**SECTION 96A OF THE TOWN AND COUNTRY PLANNING ACT 1990 (AS AMENDED)
NON-MATERIAL AMENDMENT TO PERMISSION REF: 2022/62/93154/W TO AMEND APPROVED DRAWINGS TO
SUBSTITUTE HOUSE TYPES**

LAND AT PENISTONE ROAD, FENAY BRIDGE, HUDDERSFIELD, HD8 0WA

Please find enclosed a Section 96a application to amend permission ref. 2022/62/93154/W on the above site to amend approved drawings to facilitate the substitution of some of the house types.

Substitution of plots
57,58,61,62,65,66,67,68 with Dalton

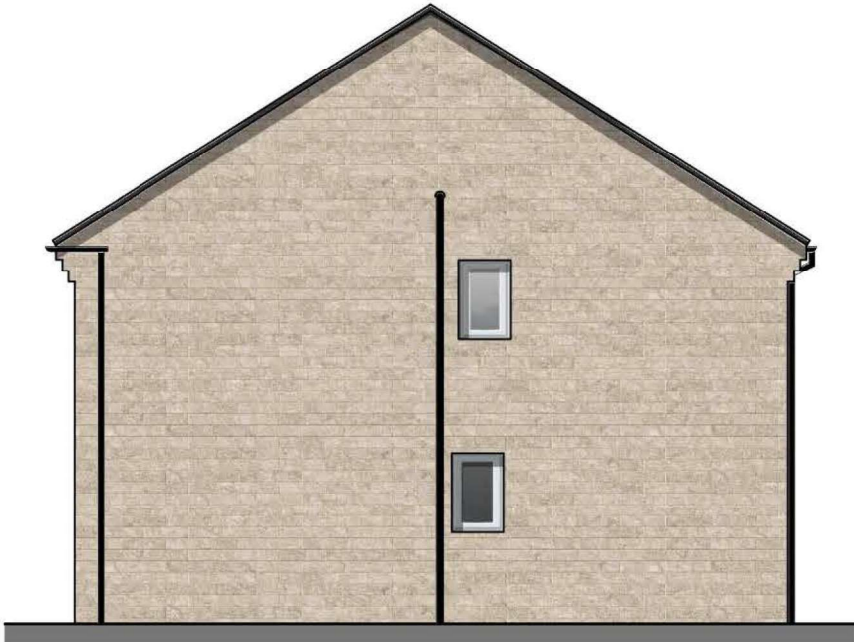
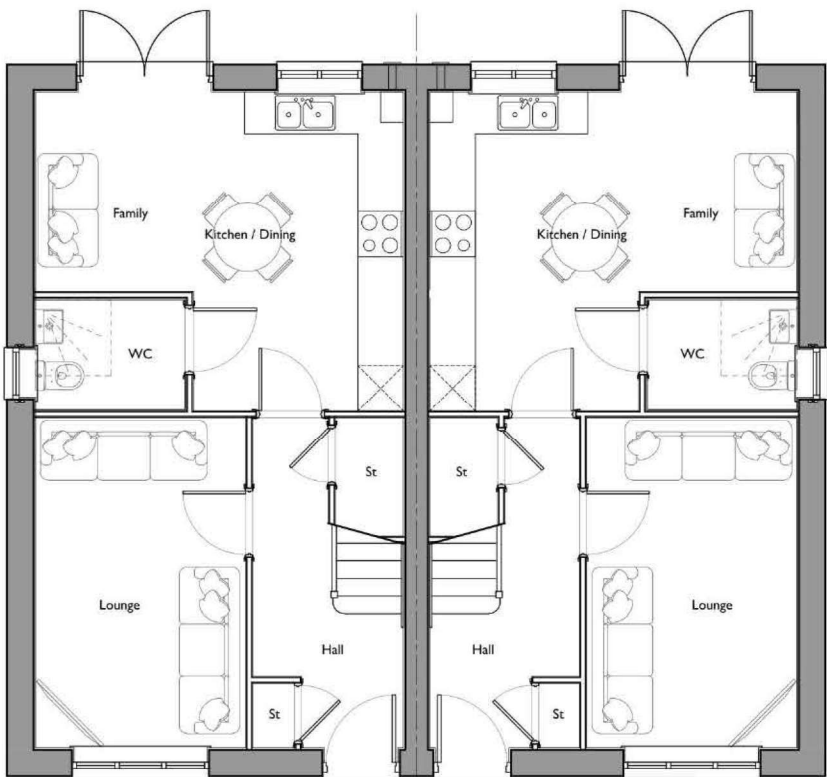
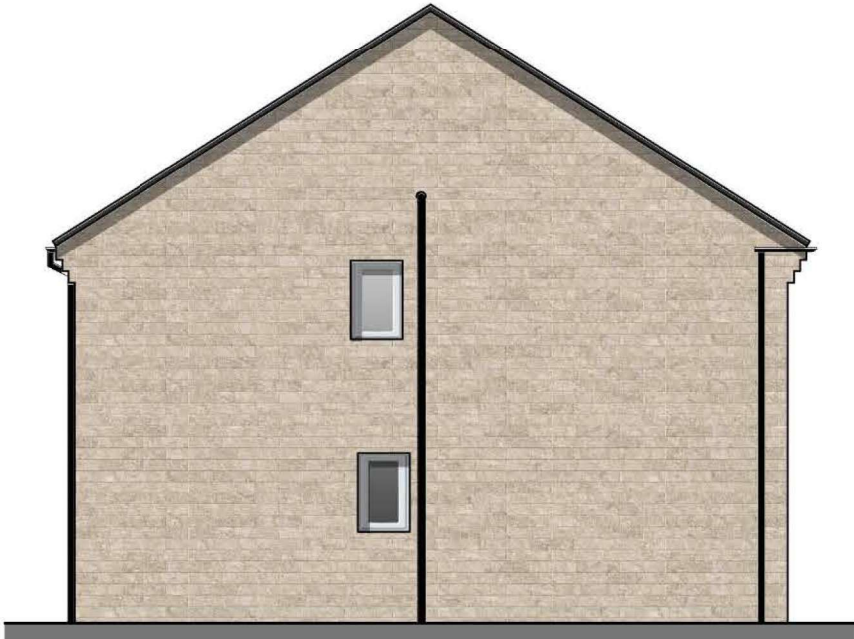
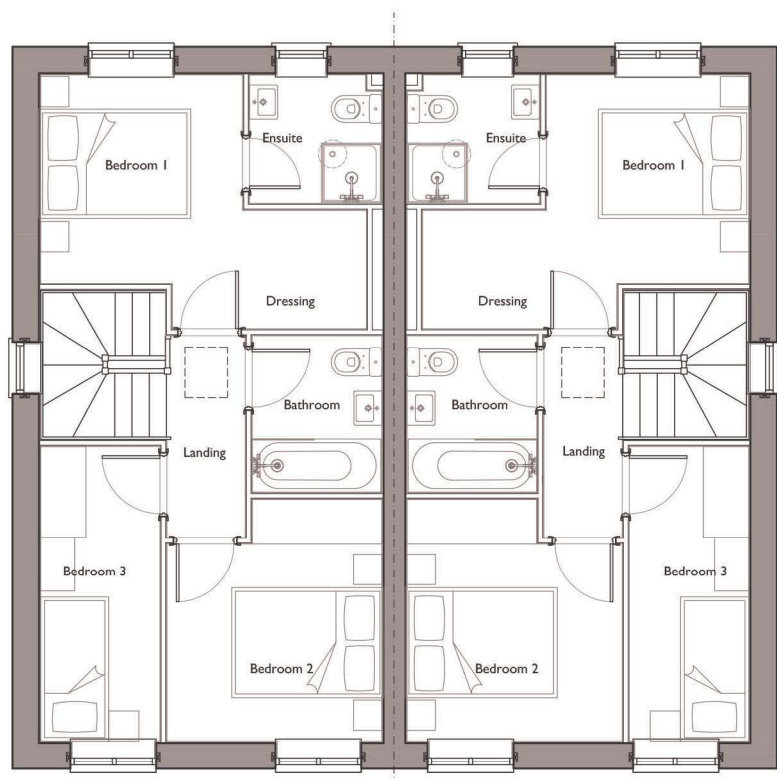
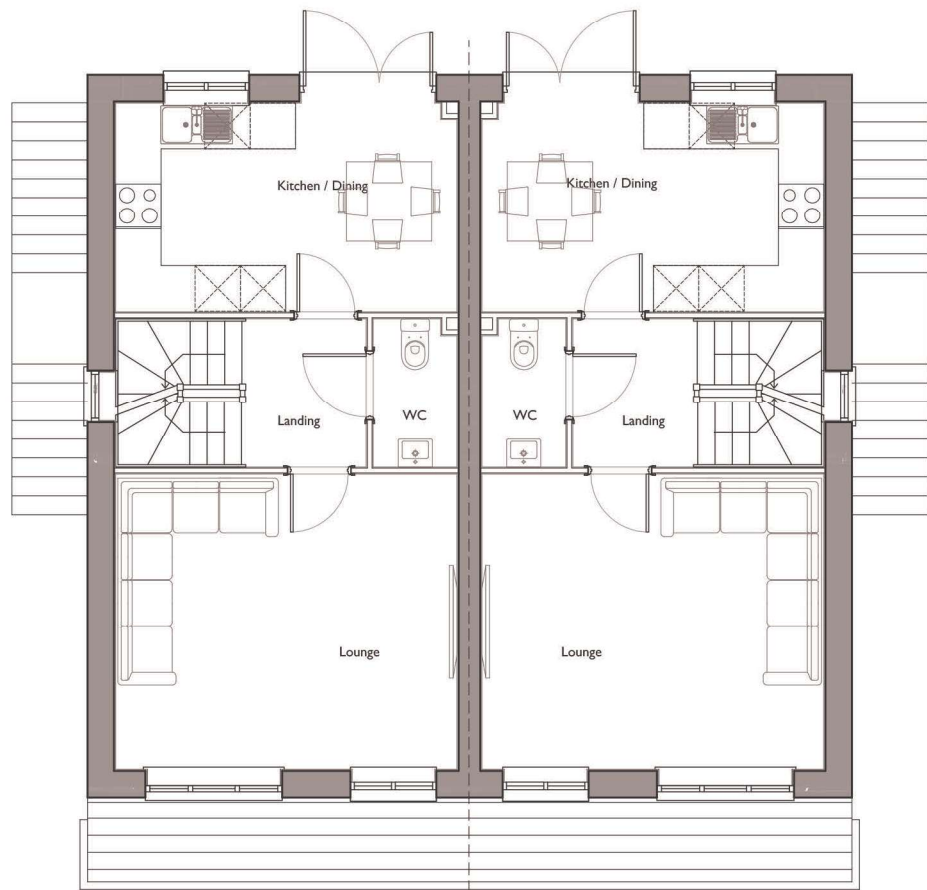
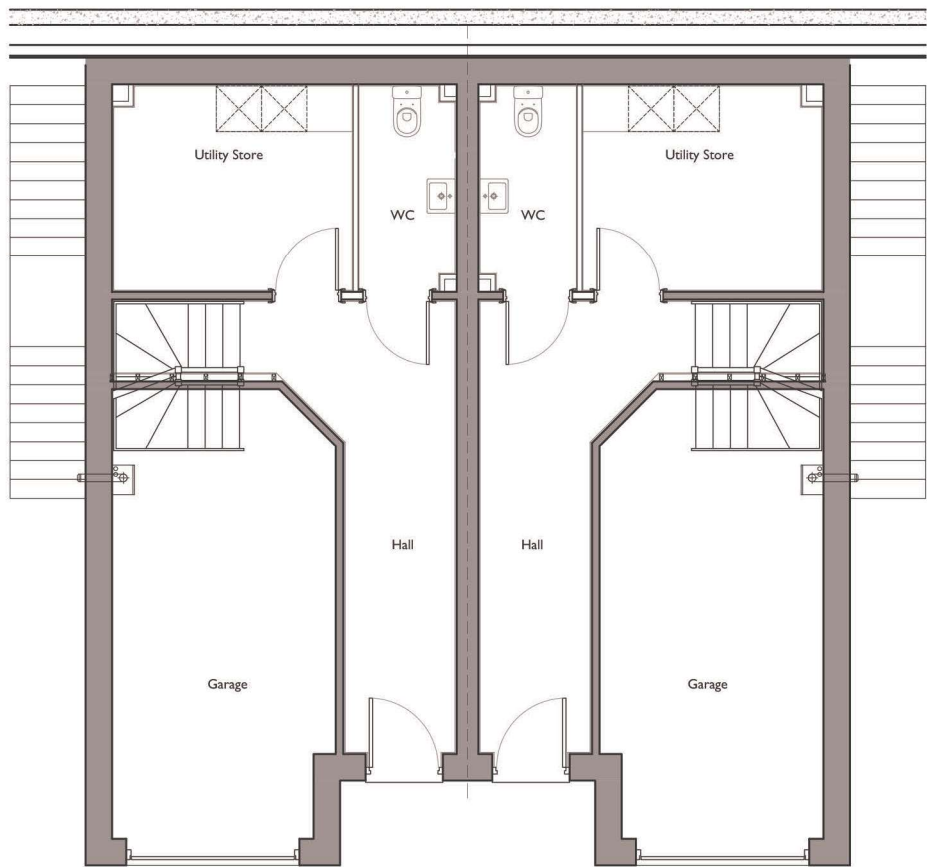
- Changes to house types on a row of houses to the eastern boundary of the site (plots 57-68) including
 - o Plots 57-58 from Fewston to Dalton
 - o Plots 59-60 and 63-64 from Fewston to Ripponden
 - o Plots 61-62 and 67-68 from Middleham to Dalton
 - o Plots 65-66 from Rowan to Dalton
- Other minor layout changes as a result.
